Application by Norfolk Vanguard Limited

Norfolk Vanguard Offshore Wind Farm

The Examining Authority's first written questions and requests for information

Issued on 19 December 2018

Drawing file: published-documents / EN010079-001743-Figure 12.08 Concurrent Piling Based on Worst Case Scenario.pdf

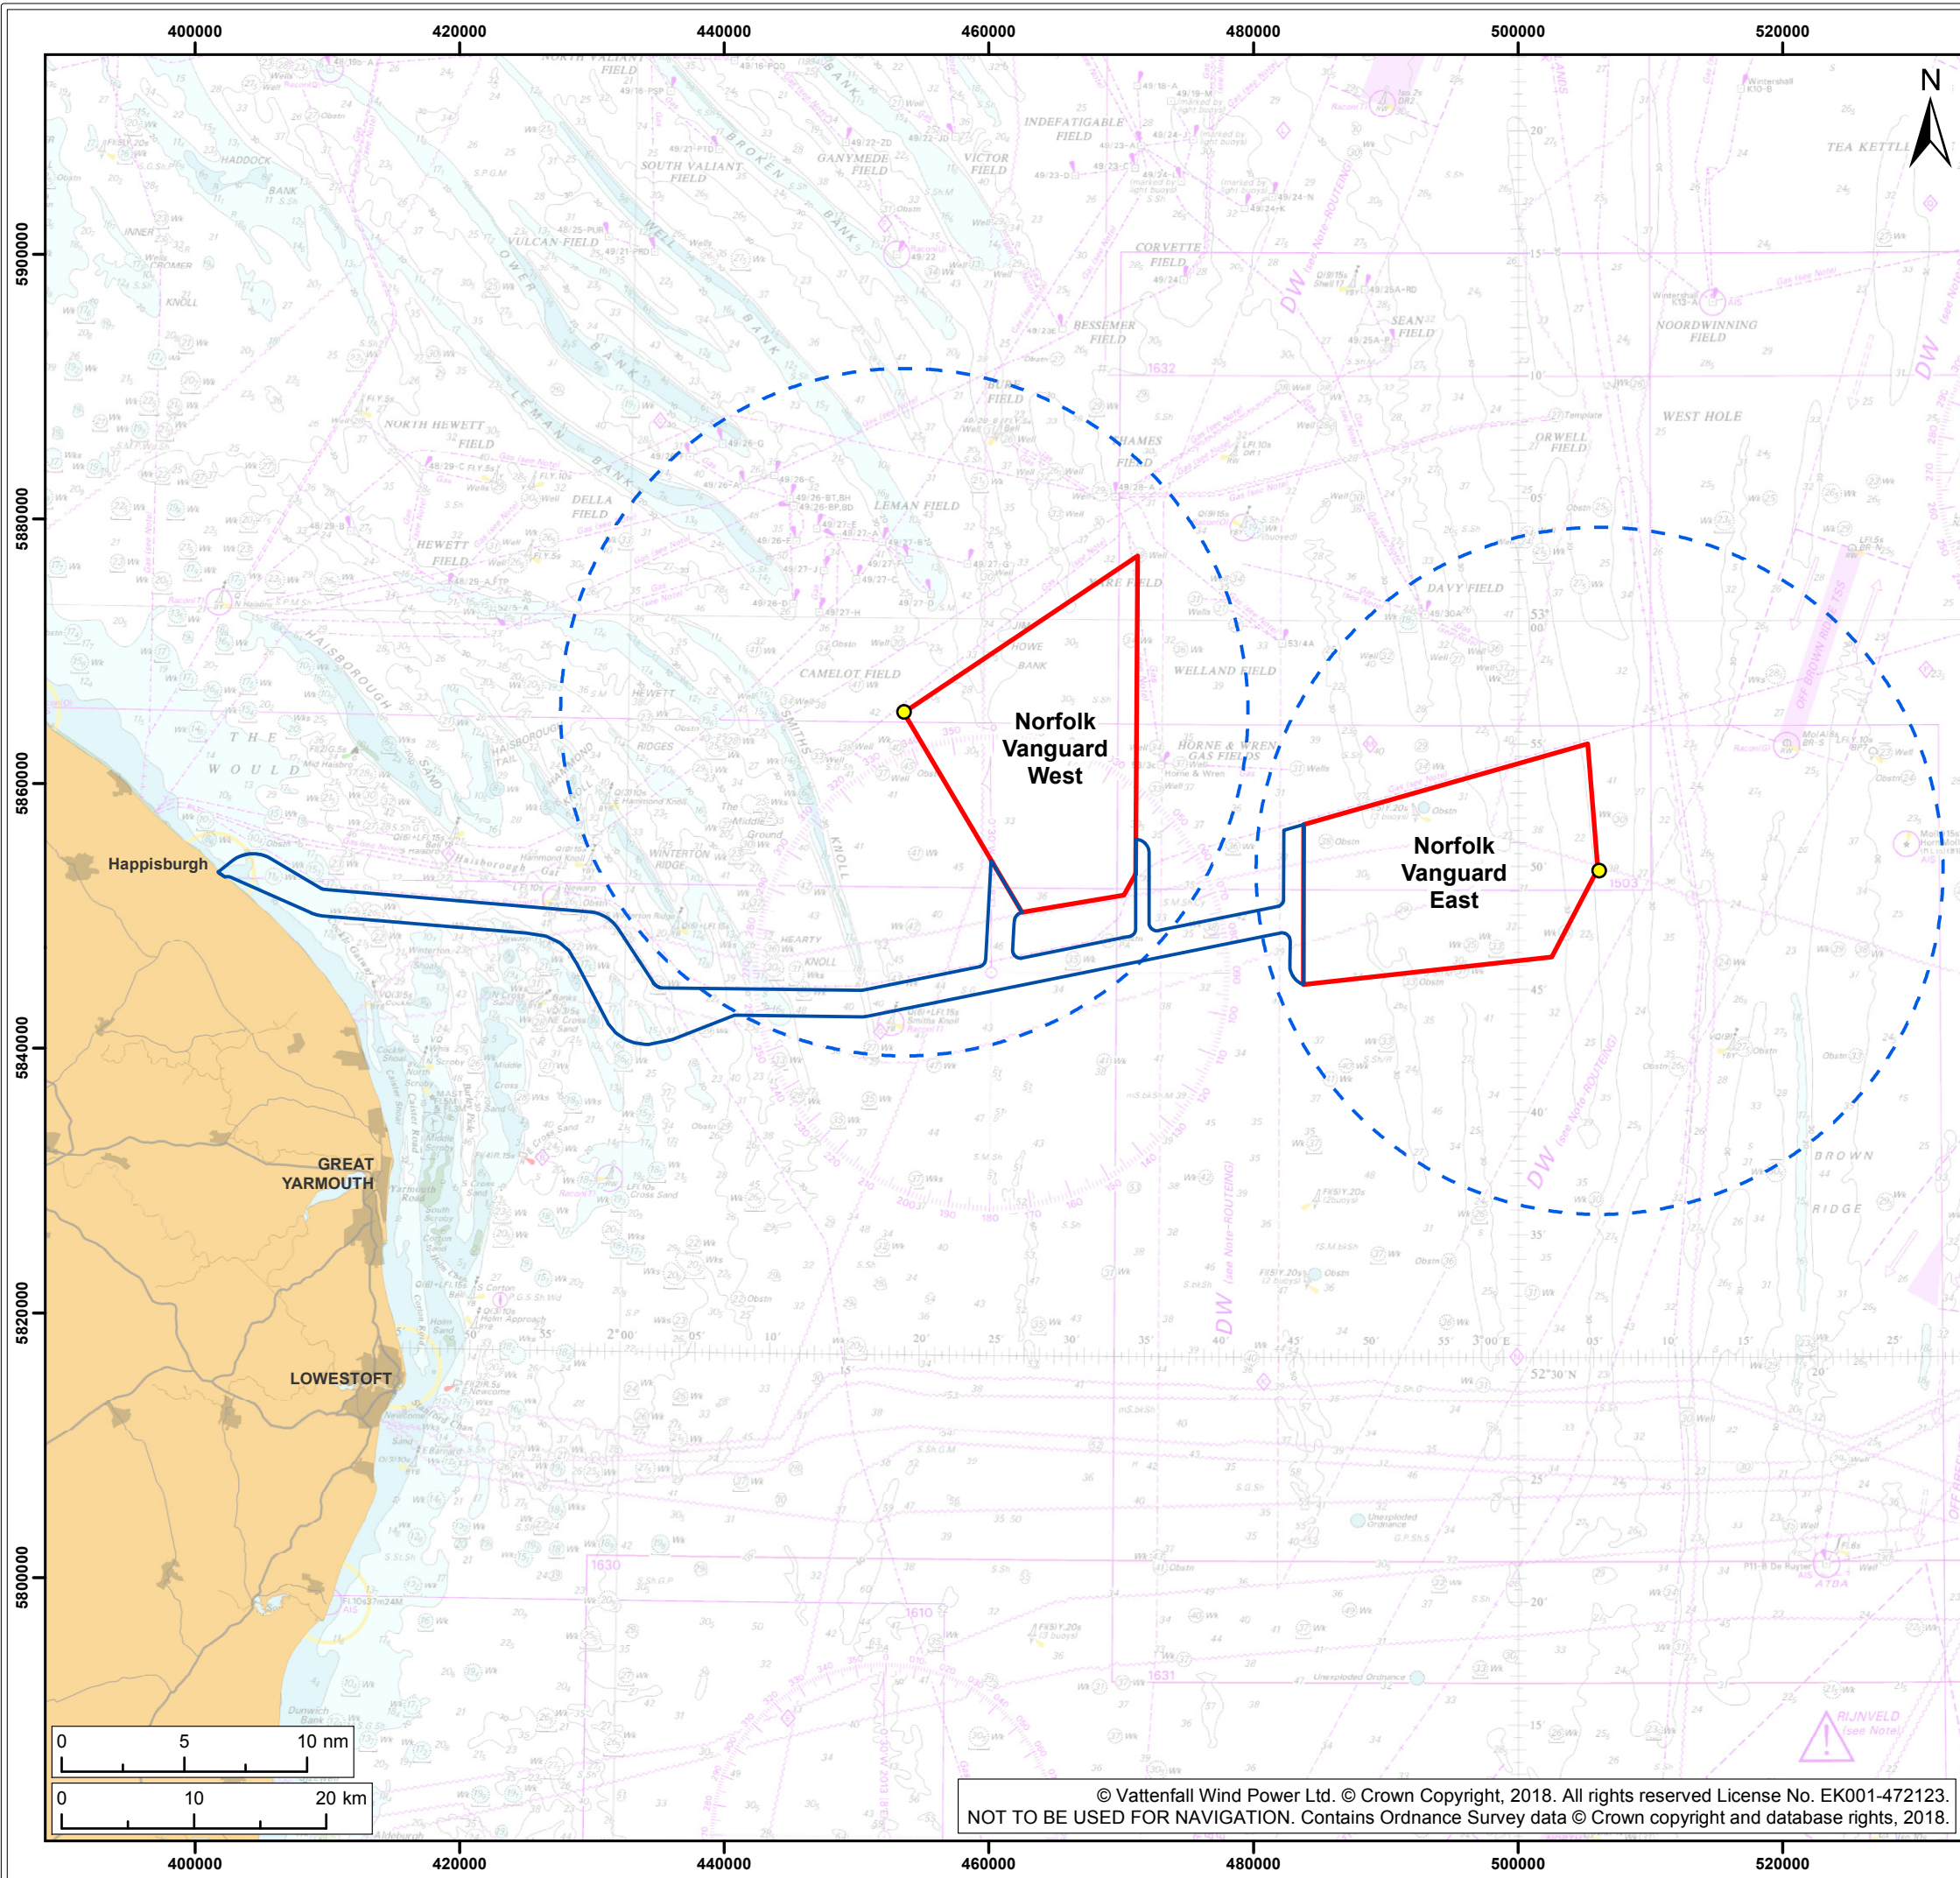
4.4	Applicant	Please provide evidence of the measures that would be put in place to ensure that no more than two concurrent piling events would take place, and set out

Question to:	Question:
		how this would be secured in the dDCO.
4.5	Applicant	Table 8.9 of the Information for the Habitats Regulations Assessment [APP-045] indicates worst case scenarios for hammer energies of 2,700 kJ for a 9MW to 20MW pin pile structure and 5,000 kJ for a monopile structure. However, these are not specified within the dDCO/DMLs. Please comment on this omission.
